Derby Cycling Group,
c/o 126, Station Road,
Mickleover,
Derby,
DE3 9FN

Date: 4th November, 2019.

Your Ref: **A38 Junctions Interested Party Written Representation from Derby Cycling Group**

Appendix 1: Derby Cycling Group NMU Checklist

Drawing Title
**FIGURE 12.3A
KINGSWAY JUNCTION
FACILITIES FOR PEDESTRIANS &
CYCLISTS INCLUDED IN THE SCHEME**

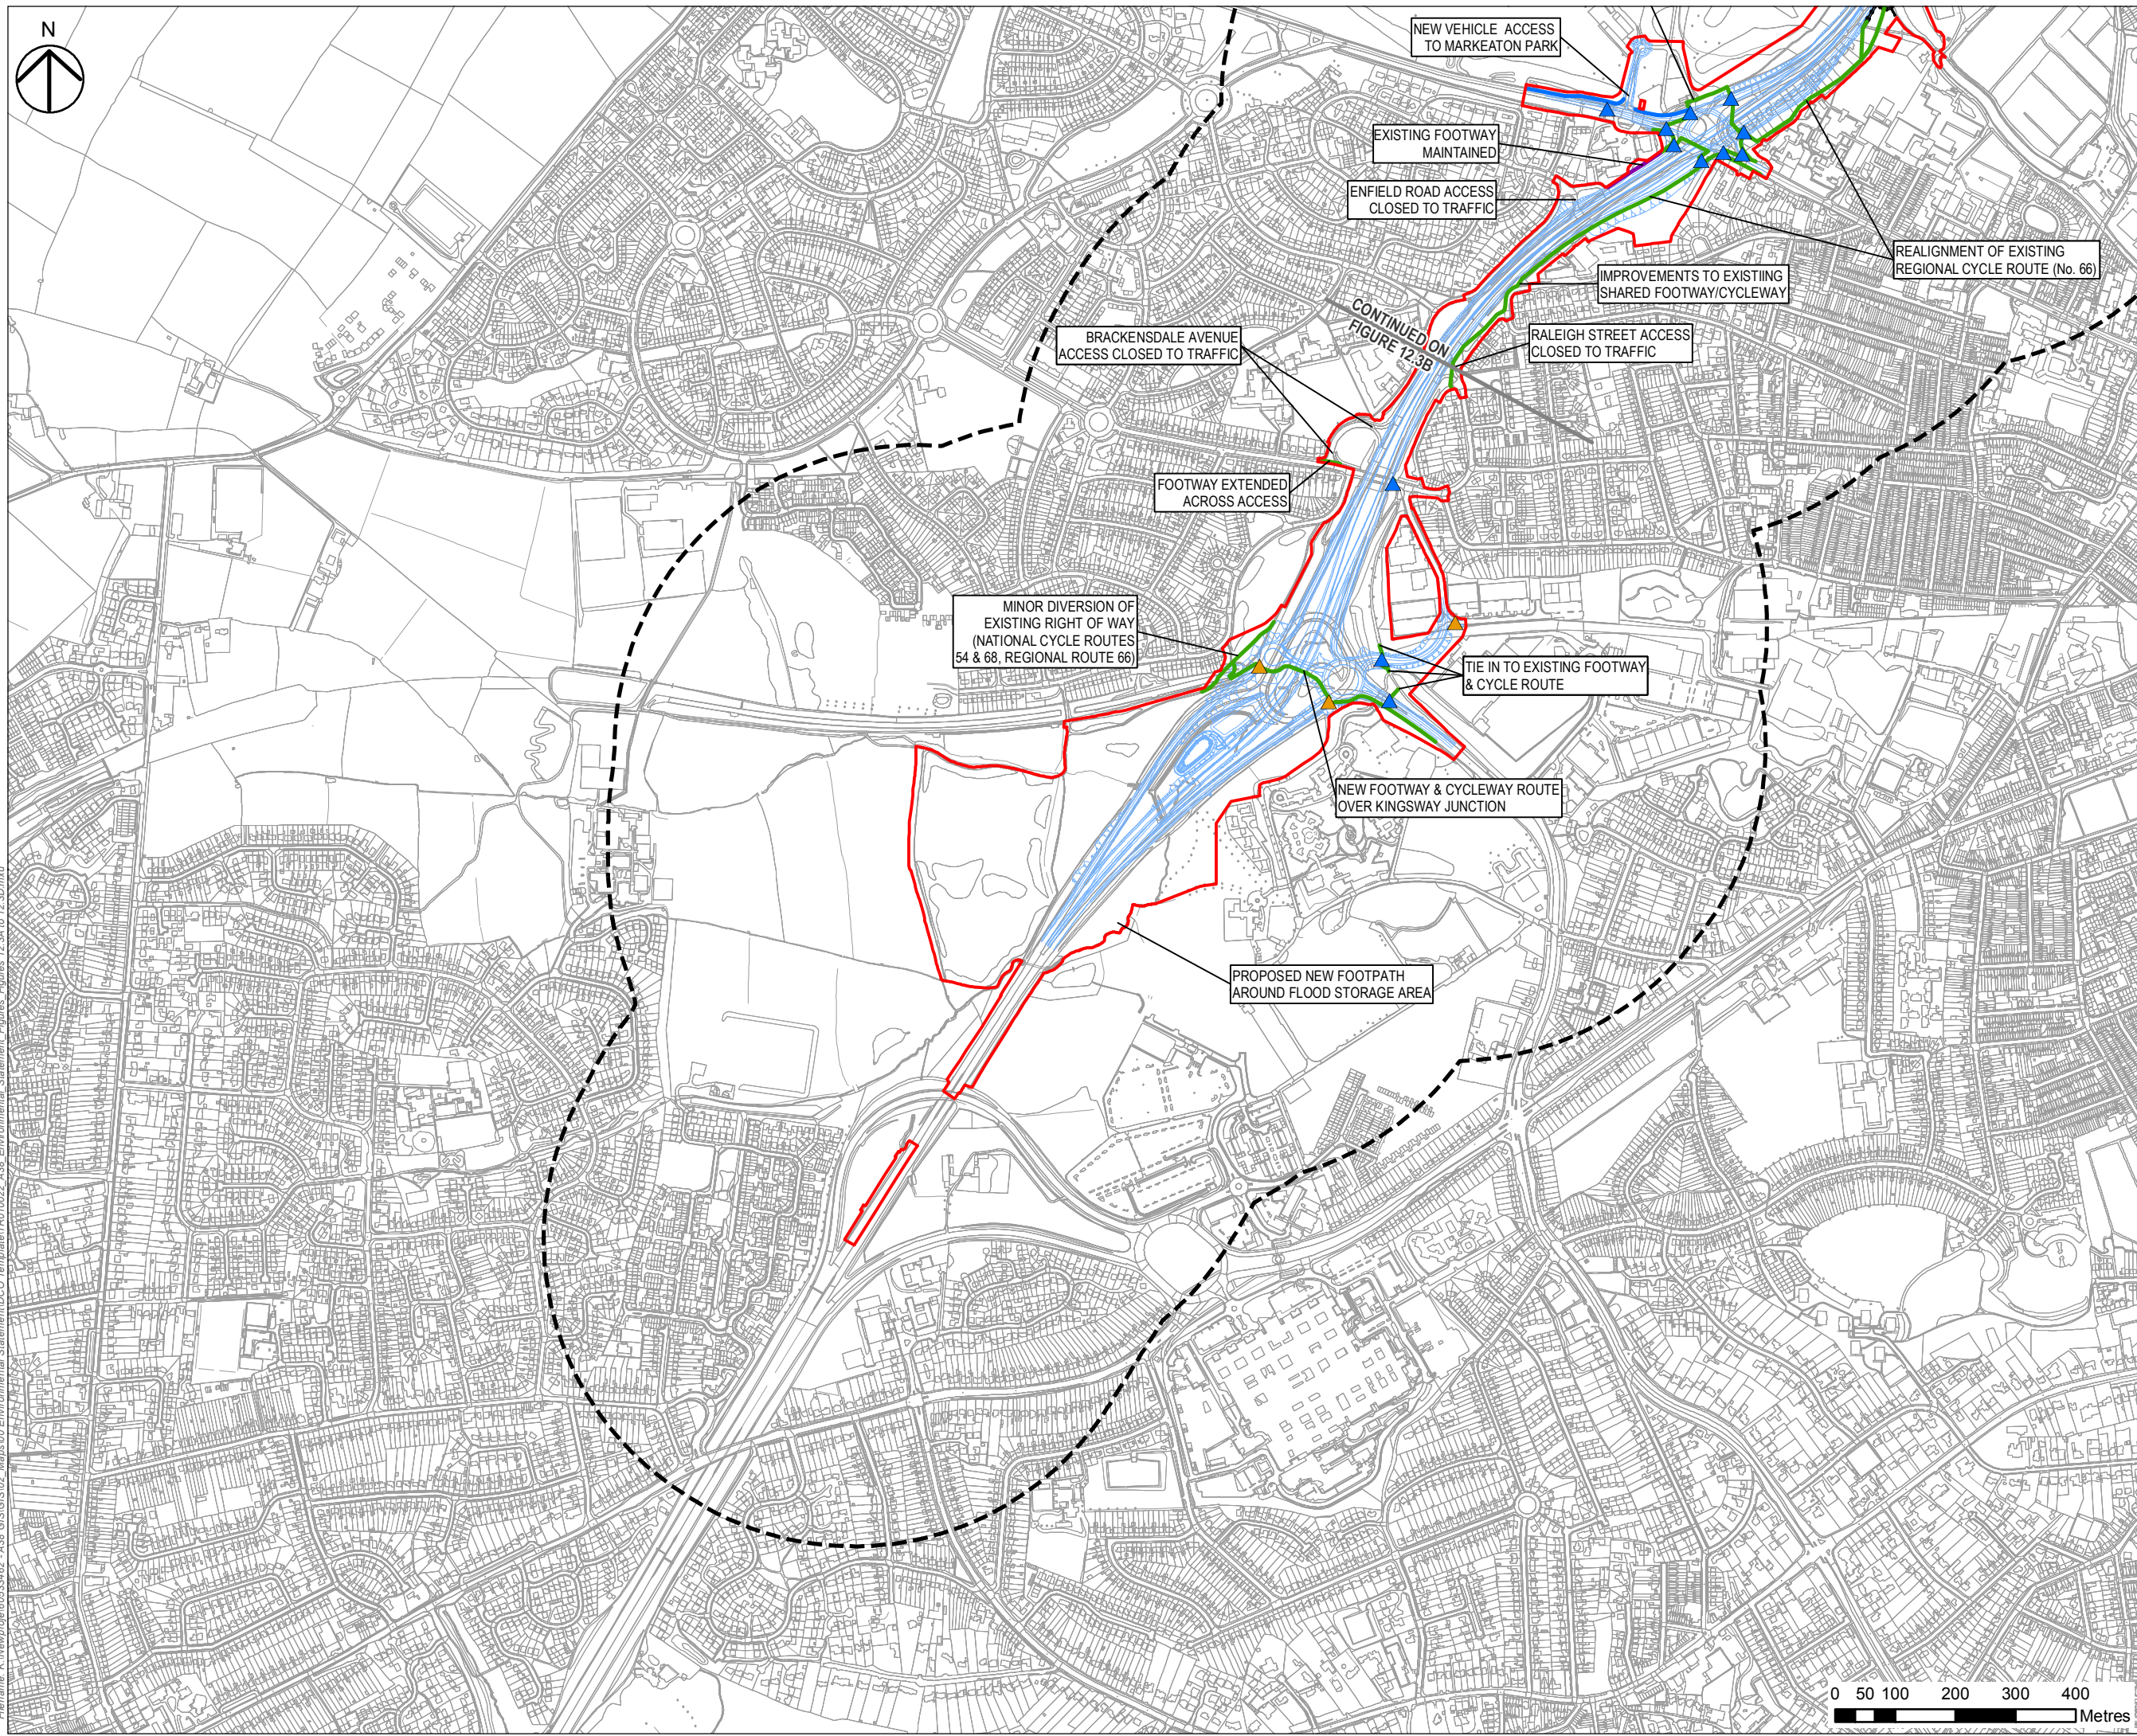
2. Kingsway/A5111 Junction			
	Retention of the cycle path along the eastern side of Kingsway		
	Upgrade the path along eastern side of Kingsway from Markeaton Island to Brackensdale Avenue, creating an off-road, segregated path. The existing, "bitty" route can be simplified due to the closure of the Raleigh Street access onto the A38, by retaining the path alongside the A38 carriageway with access spurs to Windmill Hill/Thurcroft Close/Raleigh Street.		Design updated and route simplified on large scale plans. We need to see detailed plans.
	Upgrade the path along eastern side of Kingsway from Brackensdale Avenue to the A5111 part of Kingsway (at least beyond the new crossing linking with Kingsway Park Close) to create a continuous, off-road segregated path.		This is marked as outside the scheme area.
	Install a NMU priority crossing (ideally signal controlled, at least a parallel crossing) for the NMU routes where they cross the new link road with Kingsway Park Close		Plan updated to include a controlled crossing. Type not specified.

Cycle access is required along Kingsway Park Close to enable cycle access to family-oriented places along there: Clip and Climb Derby, Hickory Dickory's Playhouse and potentially a new swimming pool.		Kingsway Park Close will become a busy road, and families need to be able to get access to facilities in that street by bike. Cycle paths are not planned and a parallel crossing into the side road is required.
	There need to be NMU links over the new A38 over-bridge on the A5111 to give options for people: eg Mickleover Greenway direct onto the A5111, avoiding the deviation down to Brackensdale Ave.		Path is planned, linking Manor Kingsway development with Brackensdale School
	The crossings proposed where the NMU link on the A5111 A38 overbridge crosses the A38 entry/exit slip roads need to be signal controlled so that children can safely use the route to get to school.		Uncontrolled crossings planned

The entry slip roads to the A38 southbound and onto Kingsway Park Close need to be a single lane, and not two lanes, to encourage safer driving styles and reduce speeds as drivers enter these exit points.		Aggressive driving styles and faster speeds pose problems and risks at the proposed NMU crossings at these points with dual lane exits. We recommend single lane exits to be provided; the two lanes planned will merge within a few yards into one lane anyway.
	An off road link between the existing NCN cycle path from Mackworth Park, along Greenwich Drive South to its junction with Brackensdale Avenue would provide an enhanced cycle route to Brackensdale School.		The Statement of Common Ground states that this is planned.

The crossing of Brackensdale Ave by the cycle paths on the east and west sides need to be focussed on NMUs and must give some priority over motor vehicles		This could be parallel or signal controlled crossings, with measures to keep vehicle speeds very low. A controlled crossing is only planned on the eastern side
	Create a continuous, off-road segregated shared path along the western side of Kingsway from Markeaton Island to Brackensdale Avenue.		The plans so far indicate a messy route, sometimes on-road, sometimes off-road. This route facilitates family walking and cycling journeys to Markeaton Park; parents don't like swapping off then on-road with their children. This criterion creates a simple, direct, route.
	NMU priority across the entrance to McDonalds and the Esso garage		Can the entrance to these sites be restricted to Ashbourne Road only, and tied in with the access to Markeaton Park? This would create many advantages for NMU crossings in both locations.

Ideally, the off-road segregated shared path along the eastern side of Kingsway would be continued along the A5111 Kingsway, beyond the link with Kingsway Park Close, to the Kingsway Retail Park junction.

Drawing Title  
FIGURE 2.6  
MARKEATON JUNCTION  
GENERAL ARRANGEMENT

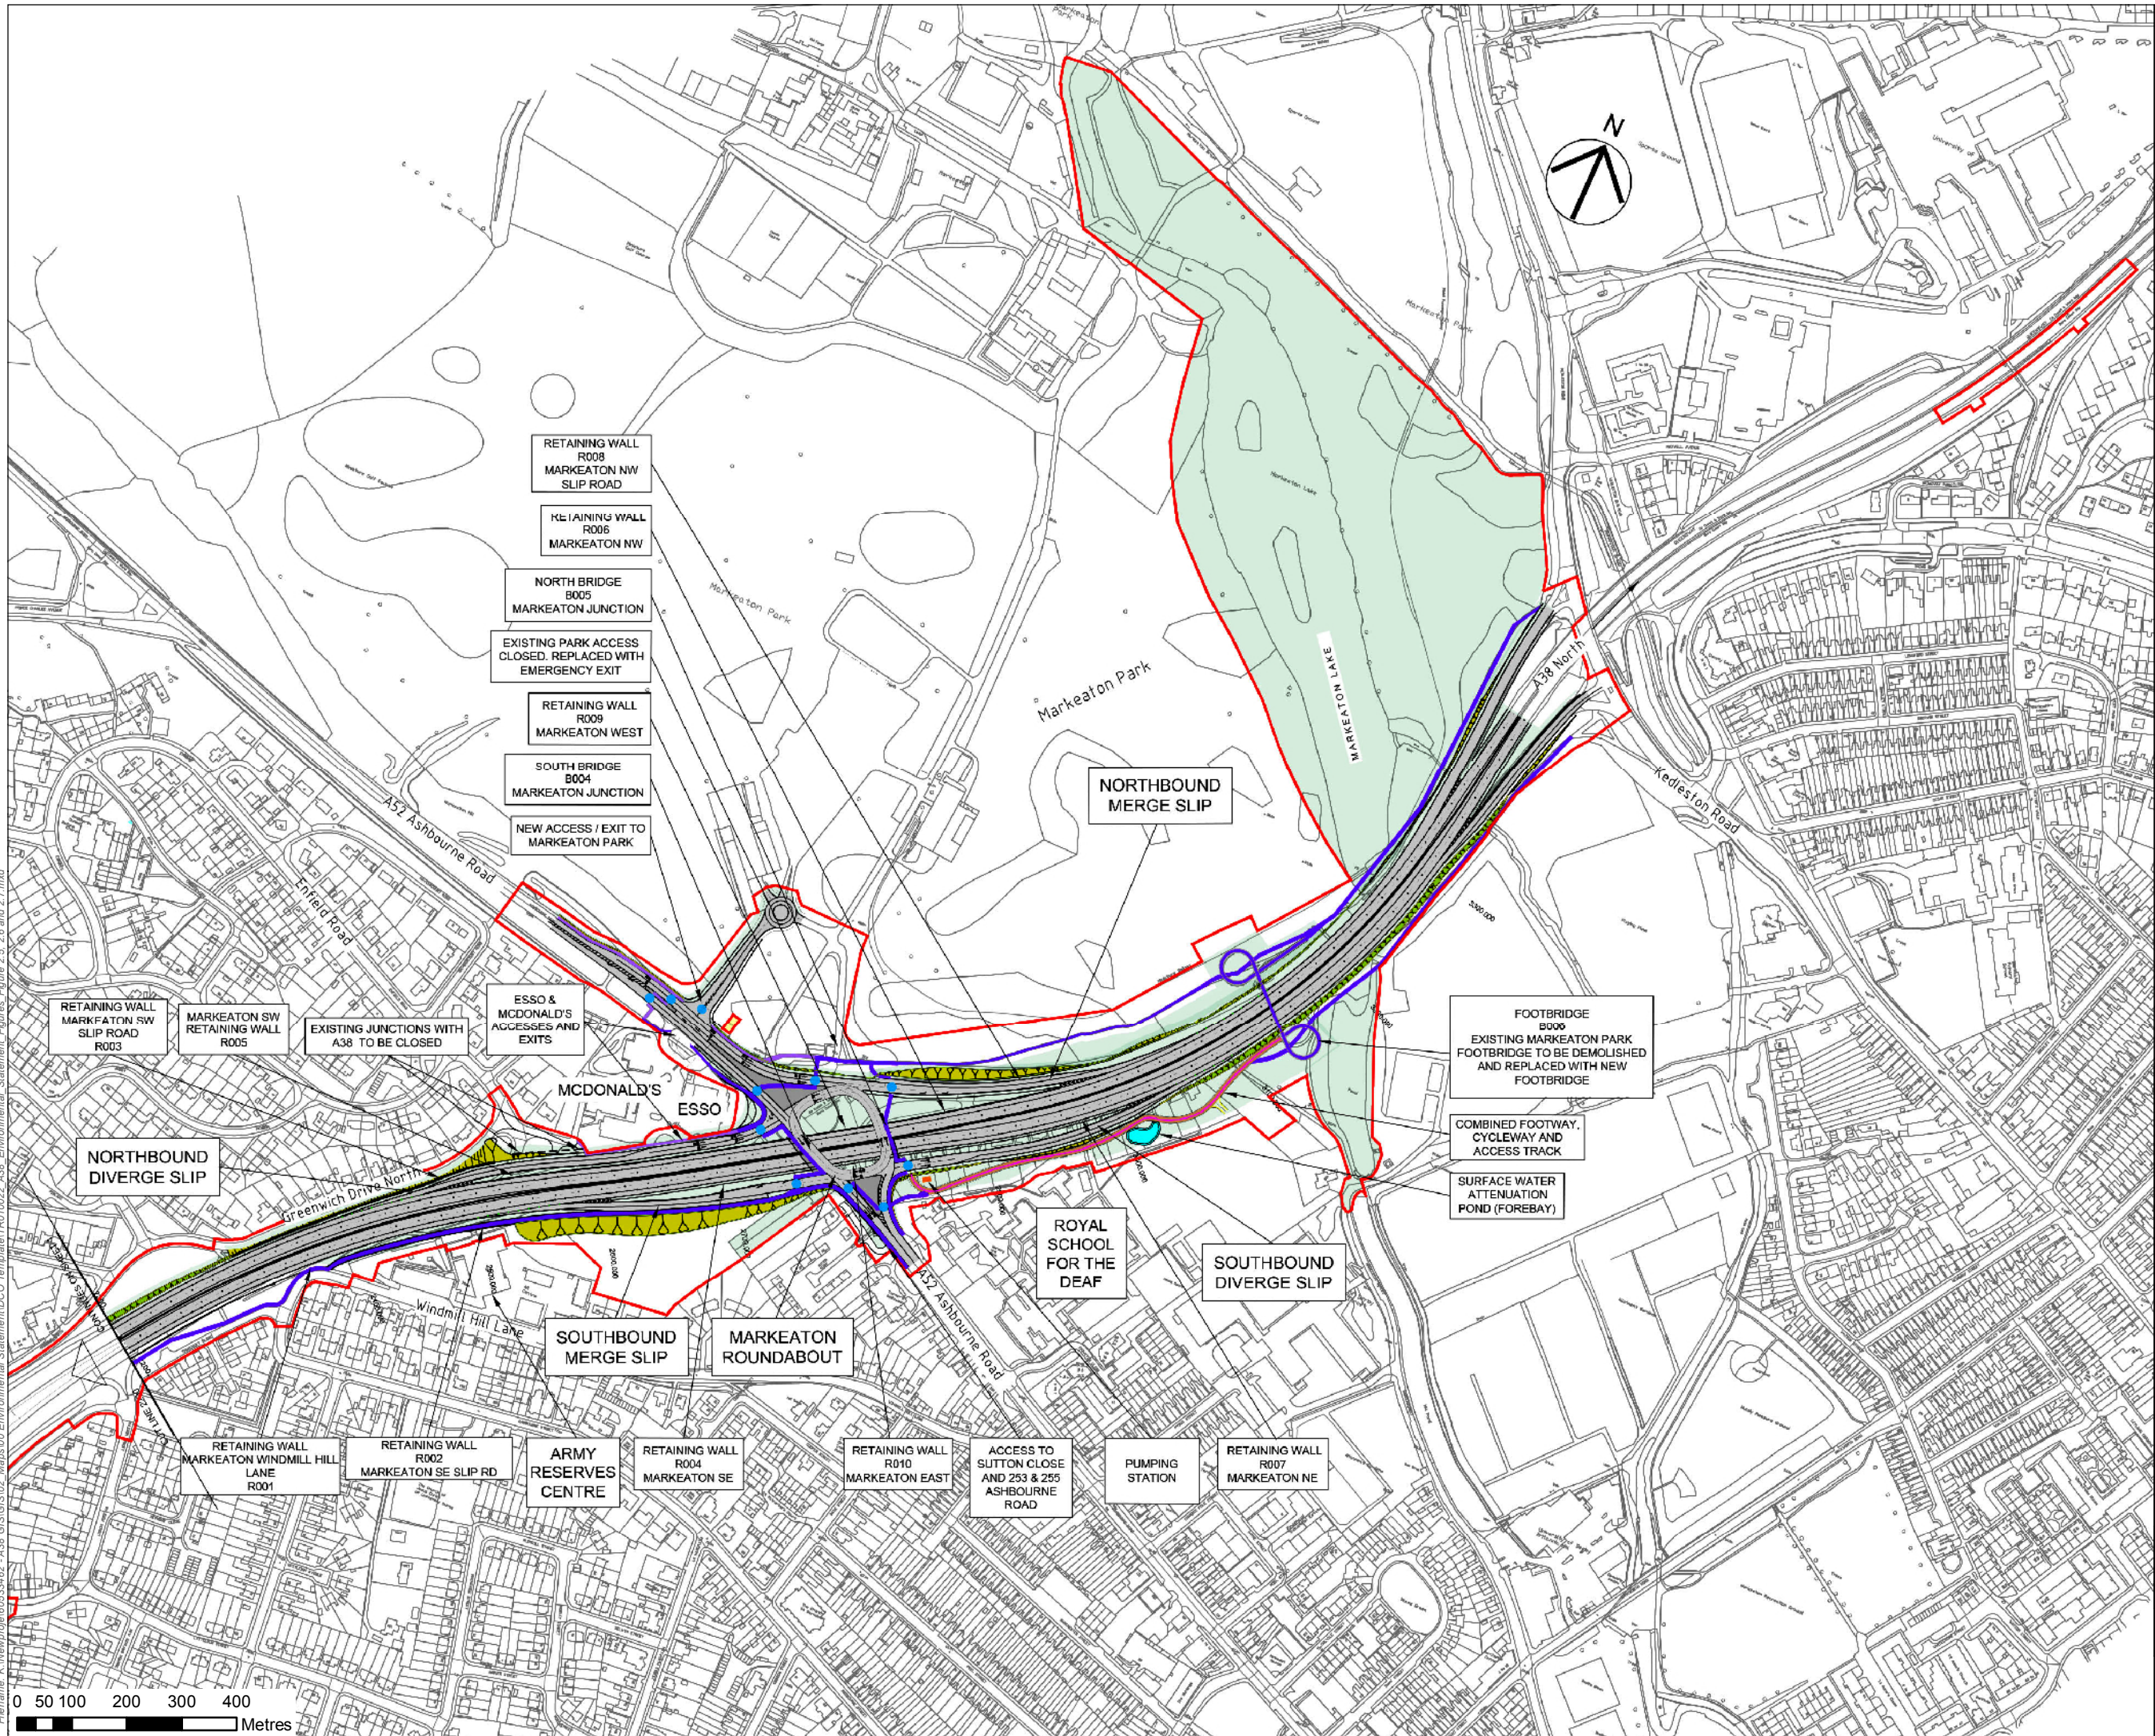
3. Markeaton/A52 Junction			
	Retain the "curly bridge" from Markeaton Street to Markeaton Park, widened (4m) with higher parapet and enhanced to enable shared use by cyclists and pedestrians		Direction of entrance to ramps should reflect main travel from/to Markeaton Street
	Signal controlled cycle crossings on all arms of the revised Markeaton Island: . Single stage crossings on Ashbourne Road in both directions		Ashbourne Road by the Esso garage is not currently controlled and is an unacceptable type of crossing for this busy, wide, fast moving, entry and exit to the roundabout.
	The NMU path on the eastern side of Queensway needs to be brought up to the national standard as part of this project.		The pathway should be upgraded but we need details of the design/width etc. There is a fence bounding it, so a 3m path is inadequate.
	The NMU path on the western side of Queensway needs to be brought up to a national standard as part of this project		The pathway should be upgraded but we need details of the design/width etc.

The junction at the top of the slip roads, on the eastern and western sides of Queensway, needs signal controlled crossings for the NMU path and a safer design for cyclists and pedestrians.		The project team say that this is outside of the project area. It needs a coordinated plan with Derby City Council
	Approaching from Derby along Ashbourne Road, there needs to be an on-road option: a cycle lane approaching the junction and an ASL/cycle box at any traffic lights, which allow riders to stay on the road to go round the roundabout. Access to the off-road paths is also needed.		Providing options for more and less confident riders. Facility is shown on latest plan, but details are needed.

When leaving the Markeaton Island on the cycle paths, any access back onto the road should be via a constriction of the main carriageway and an offset kerb, allowing cyclists to enter the carriageway parallel to traffic.		This is best achieved at the signal controlled crossing - restrict the carriageway width and route the cycle path onto the carriageway at the crossing.
